Case No. 313220

Re: Proposed SHD development on the Site Incorporating Old Dundrum Shopping Centre known as Old Dundrum Village Centre and Adjacent properties to the west of Main Street, Dundrum, Dublin 14

Dear Madam/Sir:

Fig. 4.2.2 – Lawson Criteria Results at Zone 1 of Proposed Dundrum Development

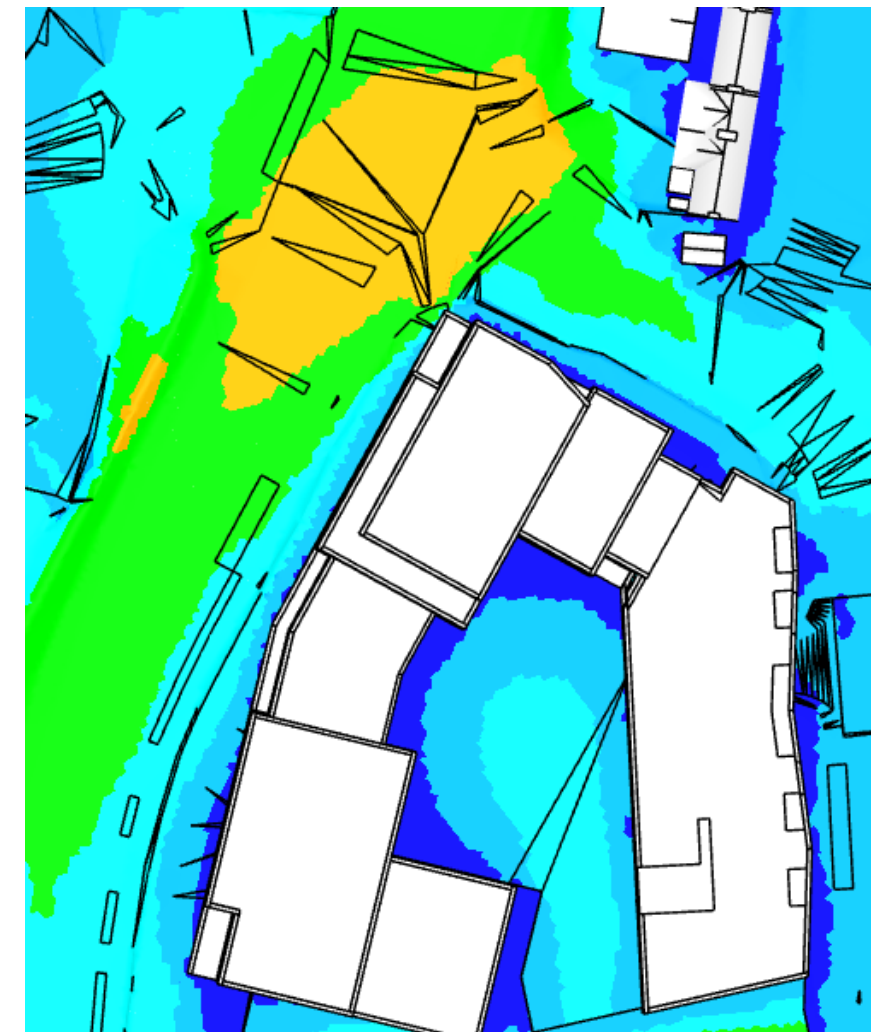
The results of the Micro-Climatic Wind Analysis **are seriously concerning**. The area to the north and west of the 16 storey building will only be suitable for 'Business Walking'. This area is already uncomfortable for pedestrians trying to cross the Dundrum Bypass with accelerated traffic levels. It would also appear to impact upon the very attractive spaces created outside Dundrum Library where a recent public realm initiative by DLRCOCO has taken place where seating and at times, a storybook installation/display, areas have been installed for the enjoyment of local residents. The impacts of the 16 storey building will seriously compromise this much loved and used outdoor public space. No mitigation measures have been proposed by the applicant.
